Recommendation Report for Planning Permission for Works or Extension to a Dwelling

REF NO: LU/44/20/HH

LOCATION: 84 Southfields Road
Littlehampton
BN17 6PB

PROPOSAL: New vehicular access & driveway.

Drawing Title
Highway Construction Details
Typical Footway Crossing

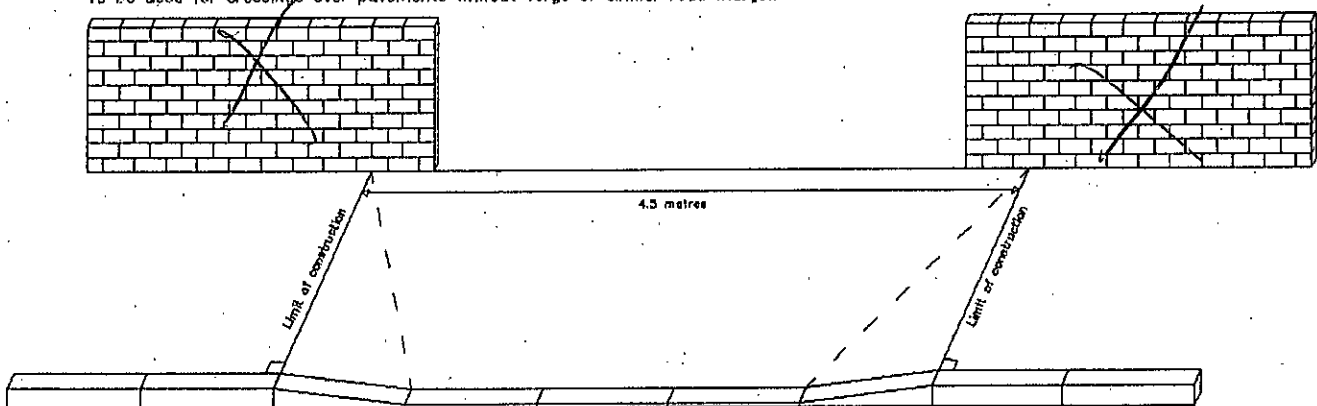
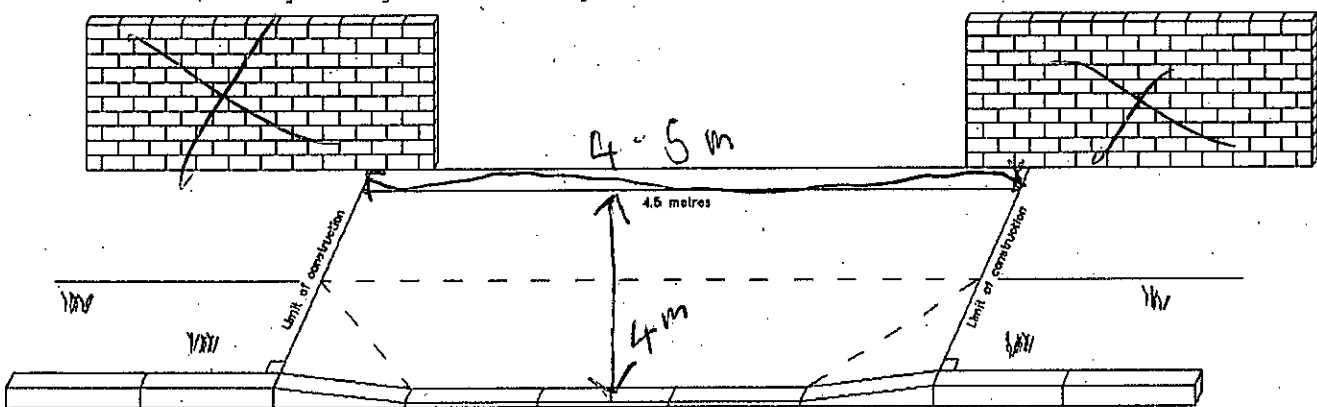
The applicant has demonstrated a drop kerb below the maximum WSCC standards of 6.4 metres.

The applicant has provided visibility splay's at the new access point. These however, are not to standards and should extend to the nearside carriageway. The Local Highways Authority (LHA) does however observe that the road has a 'C' classification with a low speed limit and traffic flow.

Vehicles exiting the back edge of the footway mean that emerging drivers will have to take account of people on the footway. The absence of wide visibility splays at minor accesses will encourage drivers to emerge more cautiously, similarly to how vehicles pull out when visibility along the carriageway is restricted.
